DEVELOPMENT FACILITATIVE TEAM (DFT)
HEARING OCTOBER 2, 2024
UPDATE: 06/05/2024 Application Submittal

Project Number PR-2024-010446
SI-2024-00774-SITE PLAN DFT

RE: Site Plan Amendment for new construction

APPLICANT RESPONSES TO THE STAFF COMMENTS:

SHOPS BUILDING
FLOOR PLAN
ELEVATIONS

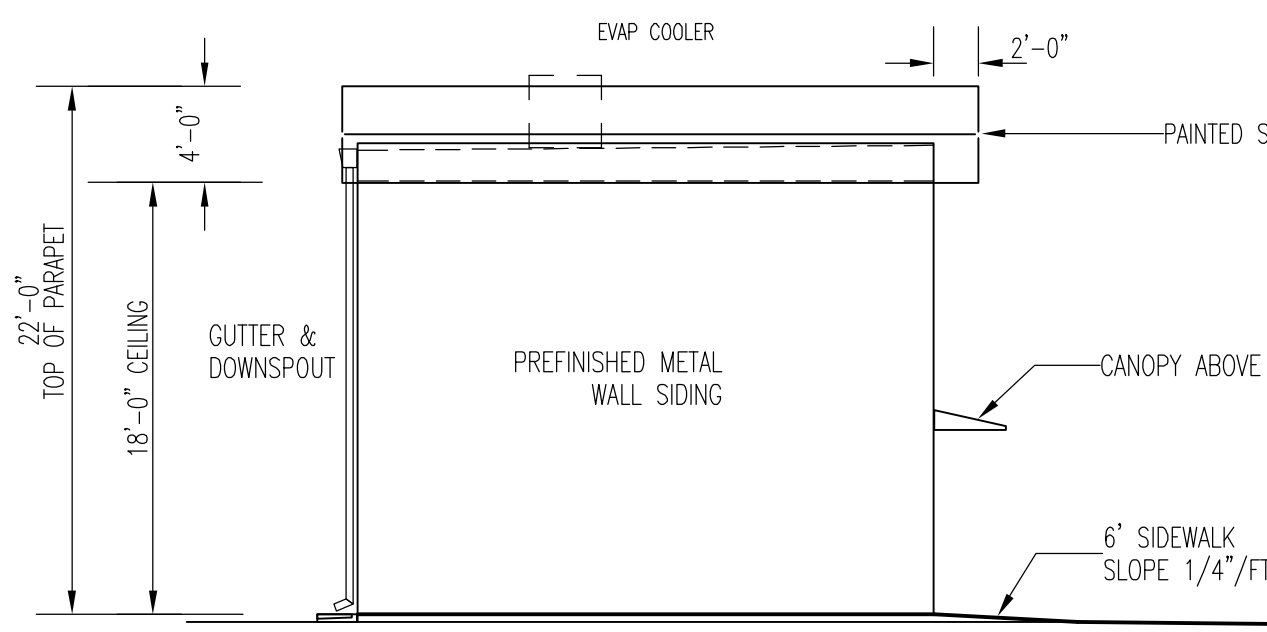
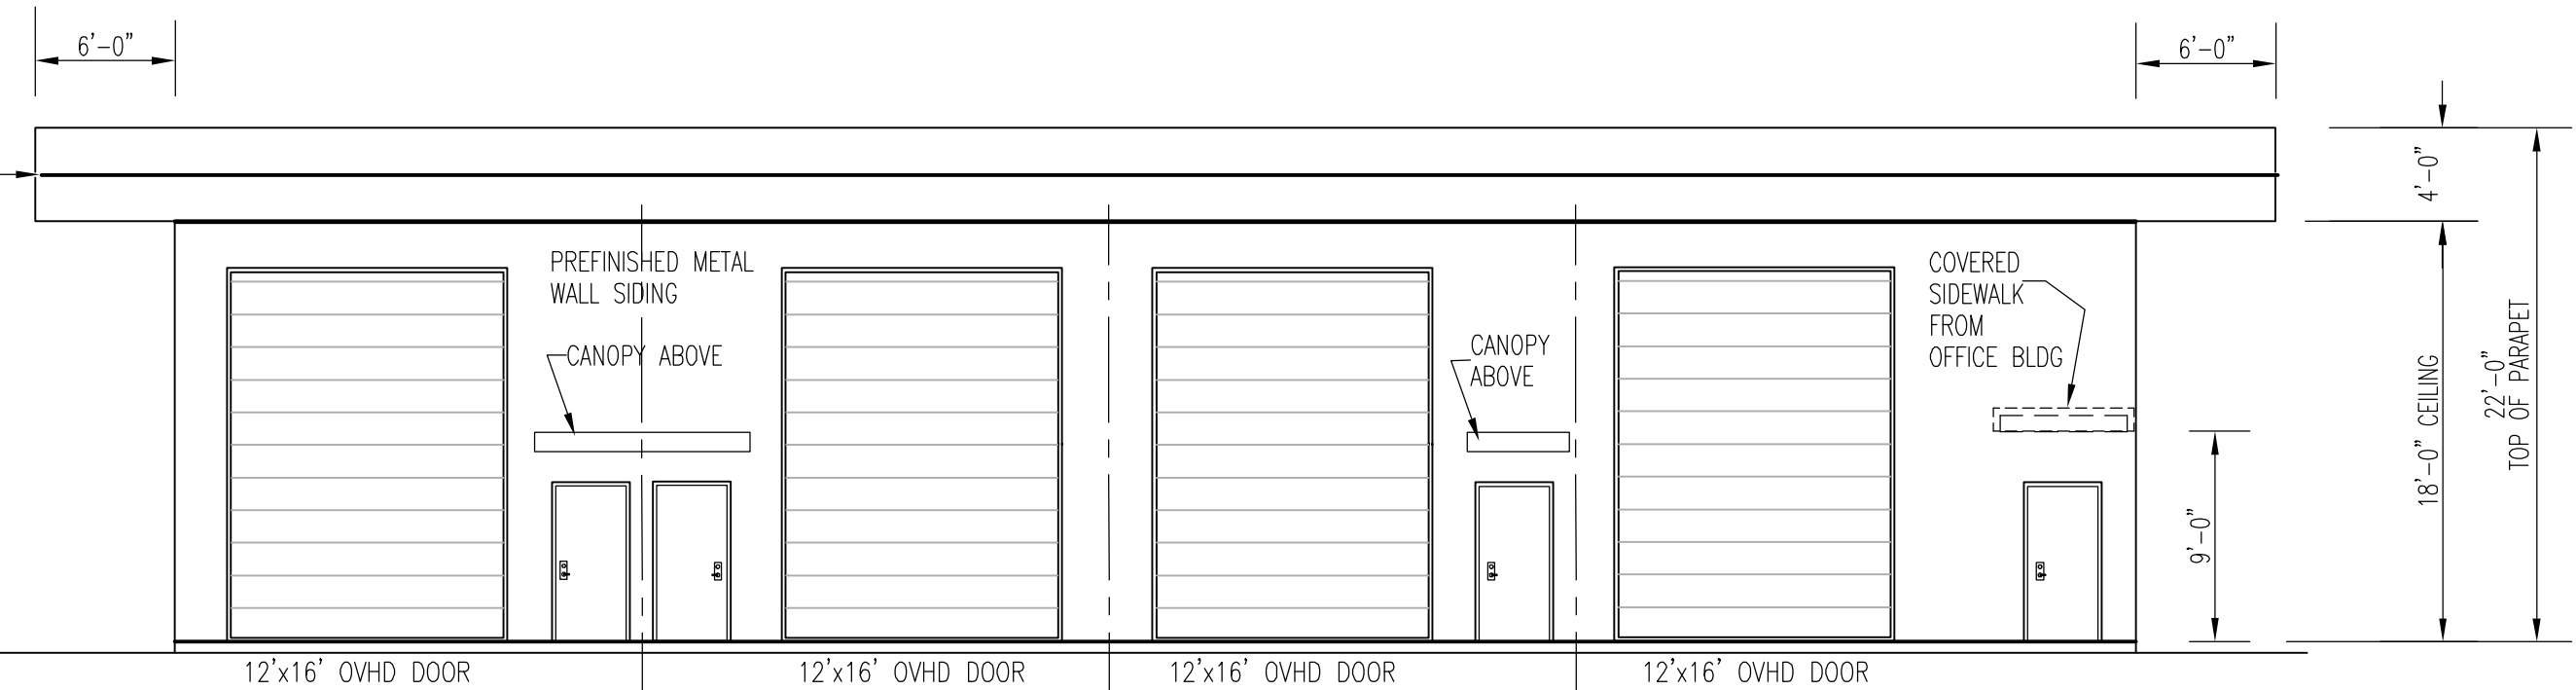
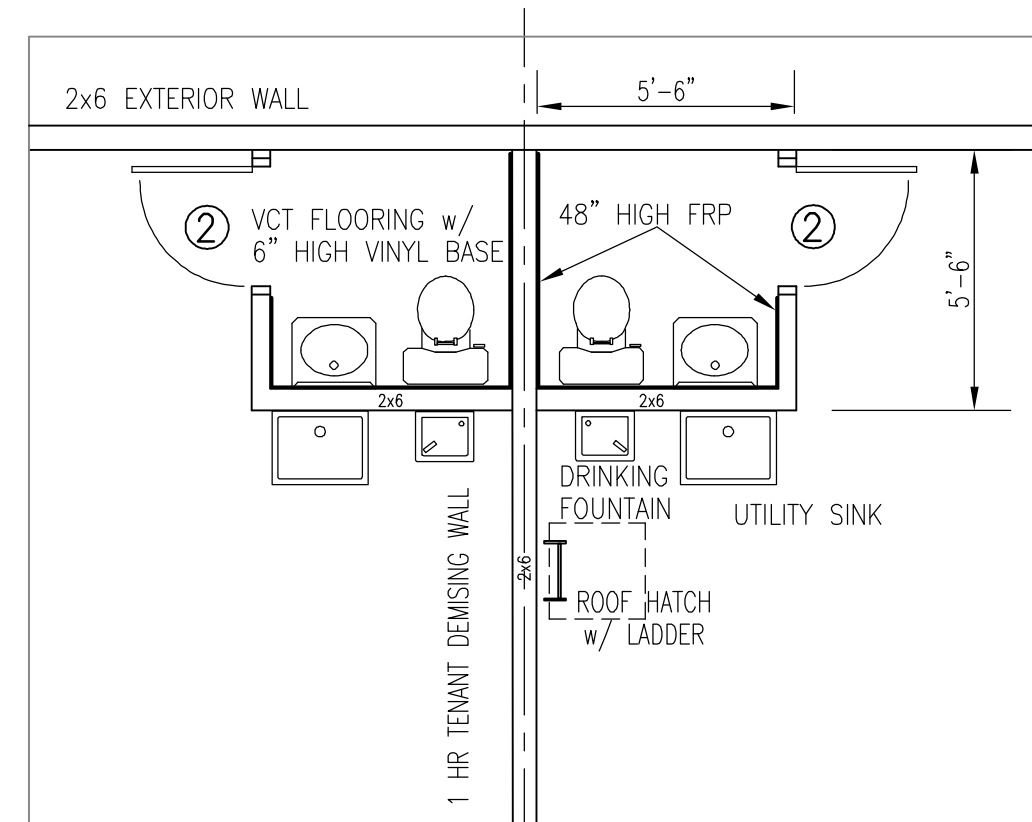
The SWPPP and the ESC Plans meet these requirements.
- The Site Plan needs to include measurements for setbacks. Elevation pages need to include measurements, dimensions, and information regarding screening, *Also clarify how the following is being met.

See drawings AC1 Site Layout Plan, A2 Office Building Elevations and A6 Shop Building Elevations.
- As a part of the elevation pages: Provide detail to demonstrate and explain compliance with all sections within 5-11-E and 5-11-E-2. Include detail regarding how the façade and colors will meet the Clifford plan design requirements.

PERIMETER METAL PANEL FENCE @ SECURE STORAGE AREA

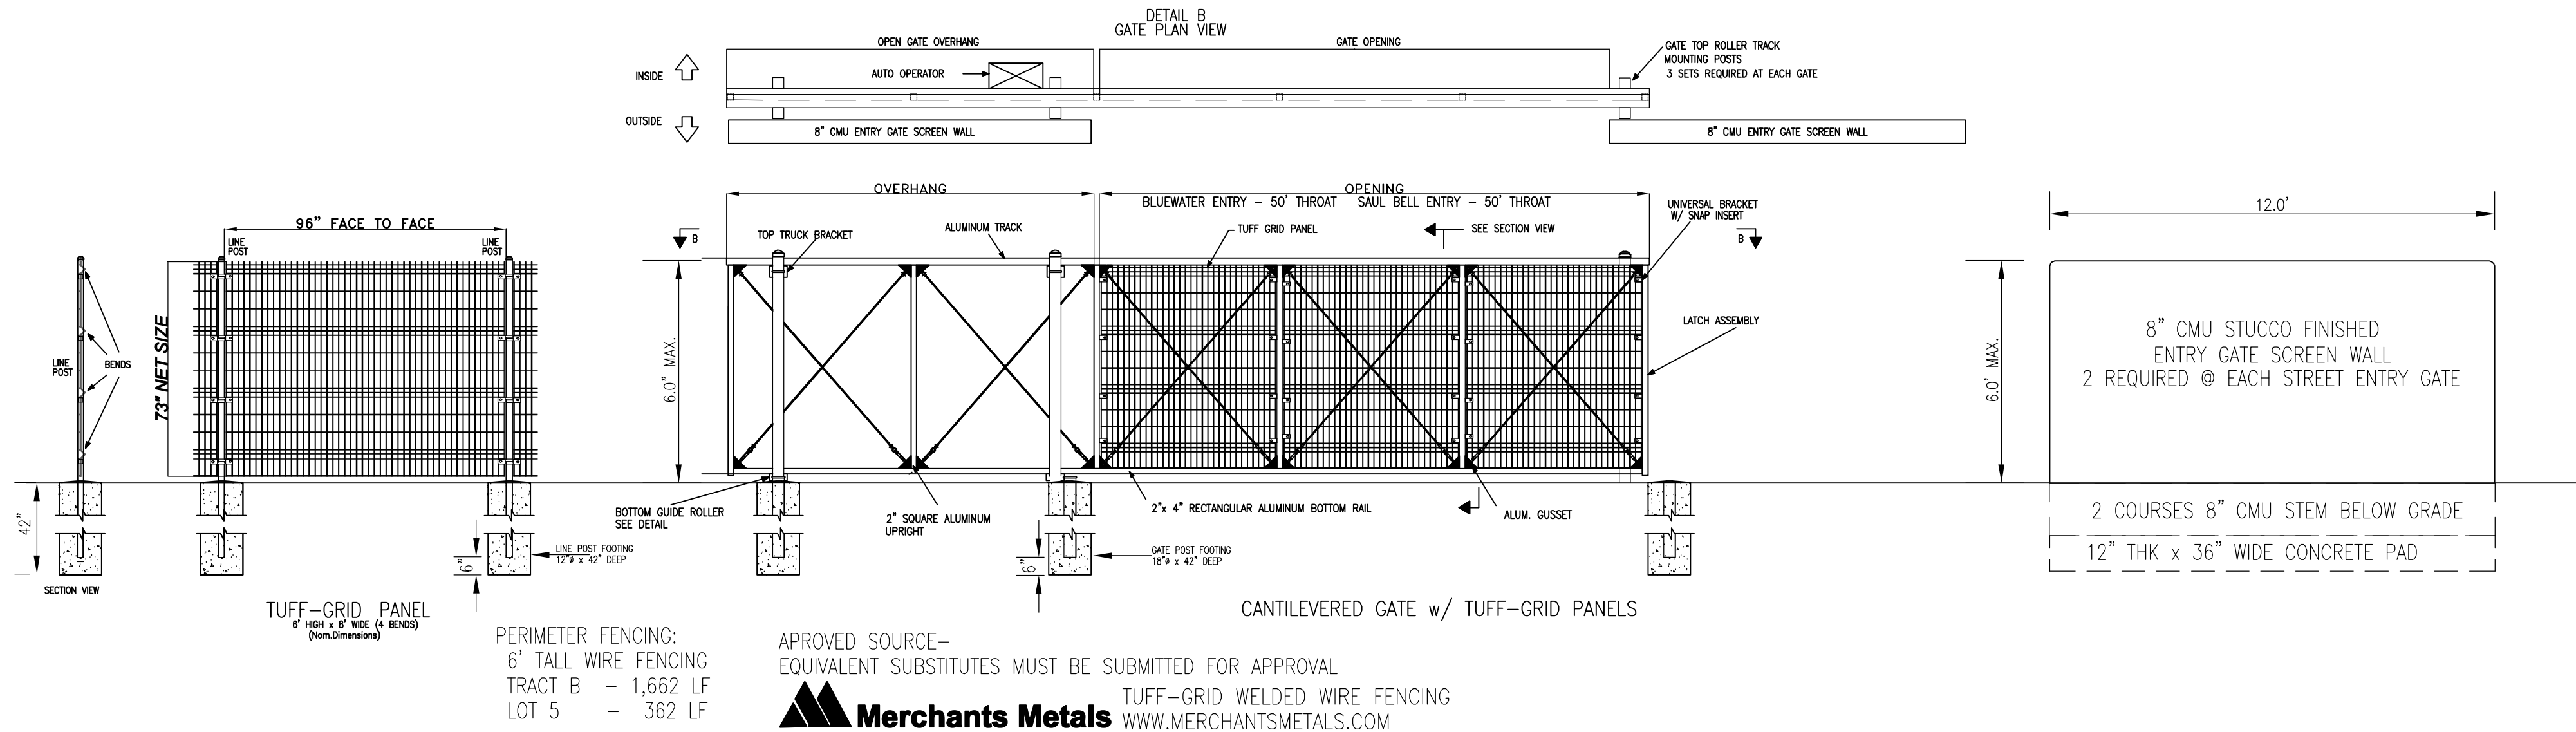
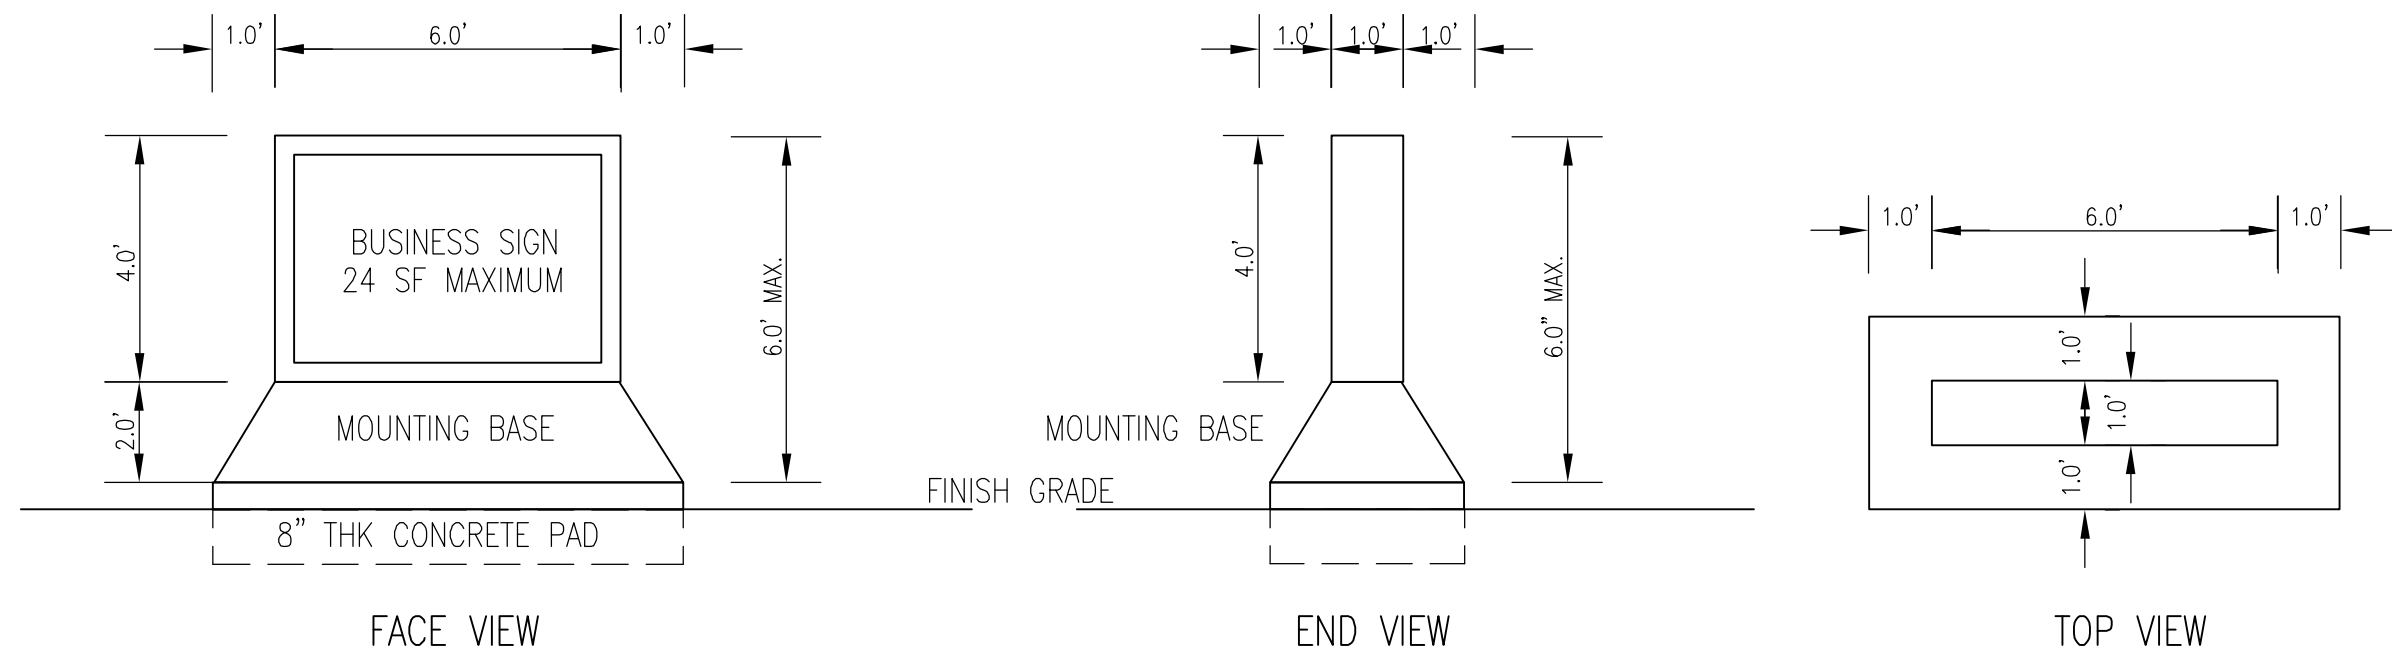
See drawing AC1 Site Plan and new Landscape Plan
- Confirm that the proposed metal fencing is meeting the material requirements of the Clifford West Plan. Walls and fences will require separate permitting through Code Enforcement and/or Building Safety. Wall/fence location and height may require additional approvals, such as a ZHE variance. *Verification per Code Enforcement and section 7 of the IDO.

See Drawing AC-2 for details. All fencing is specified to be 6' in height complying with general development regulations. Open fencing is located on the street frontage. Opaque steel panel fencing 6' high will be installed on the perimeter of the Shop Building vehicle storage area.
- Clarify compliance with the Clifford West Plan and section 7 of the DPM Table 7.2.29 regarding Sidewalk width requirements, the landscape buffer, and trails along Bluewater and Unser.

1 ELECTRICAL SITE PLAN

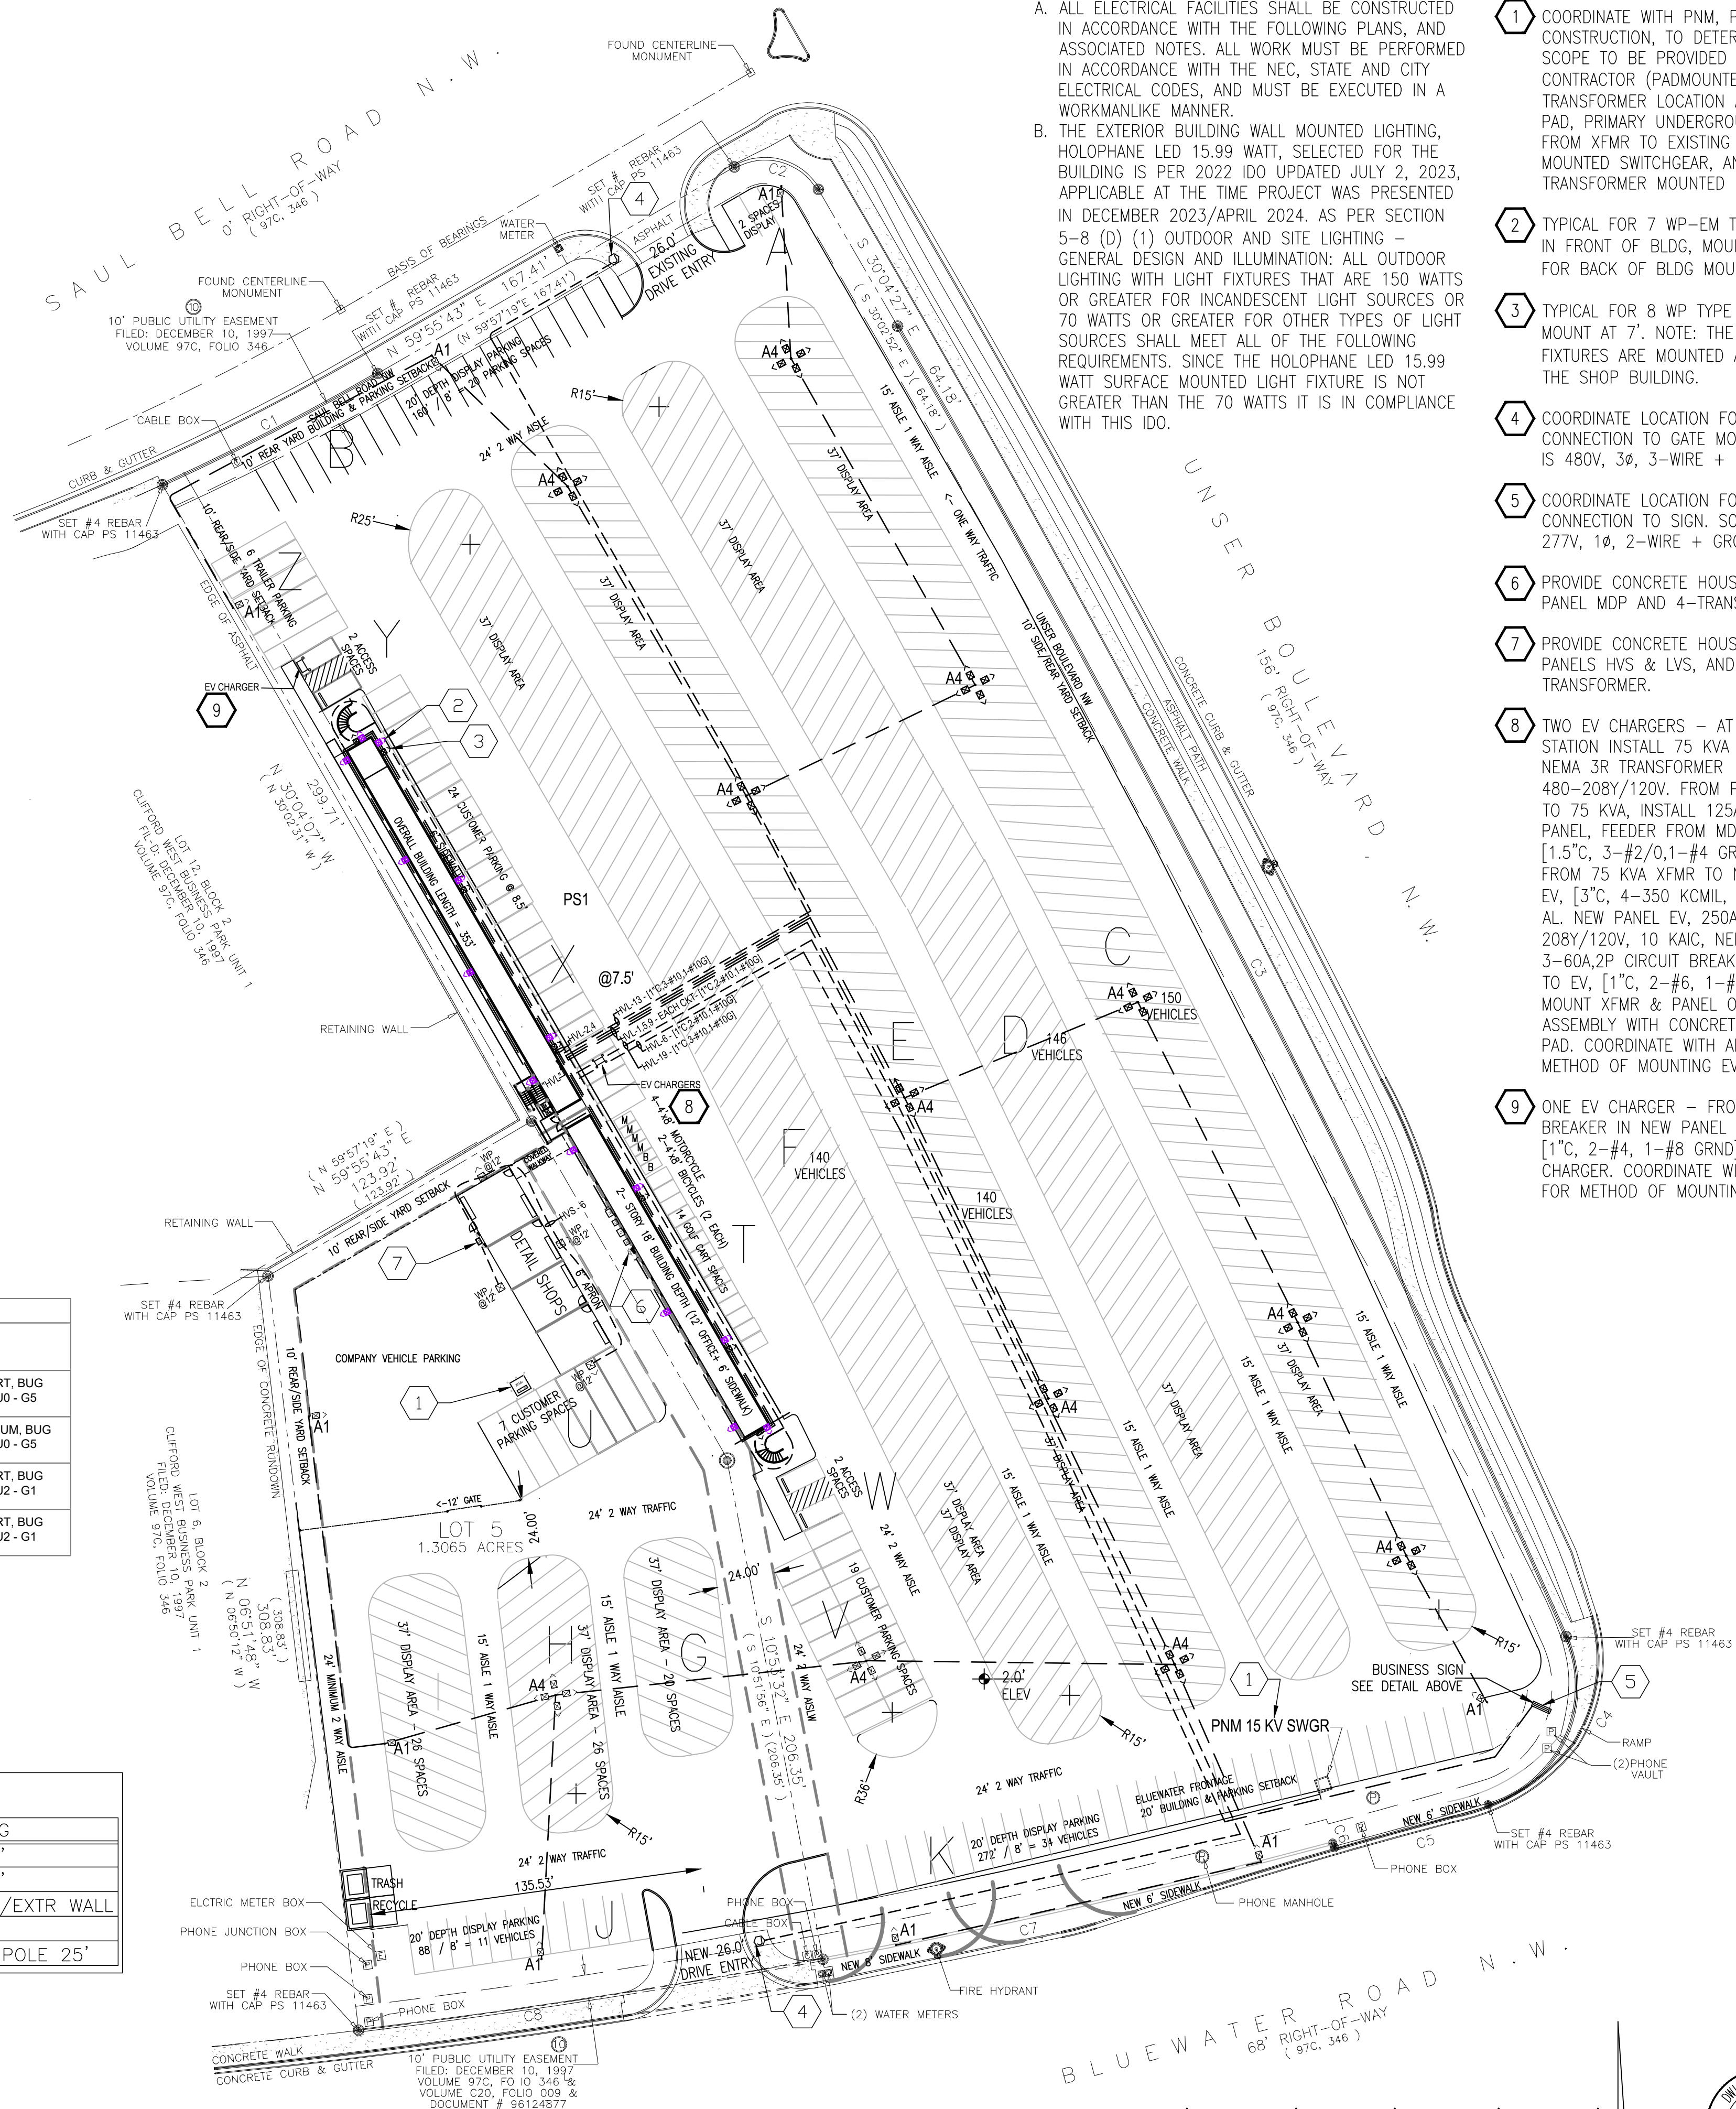
3. Provide the height of the parking lot light poles. Light poles are limited to 25 feet per master plan.

Poles are specified as 25' height as shown on Sheet E1 Electrical Site Plan.
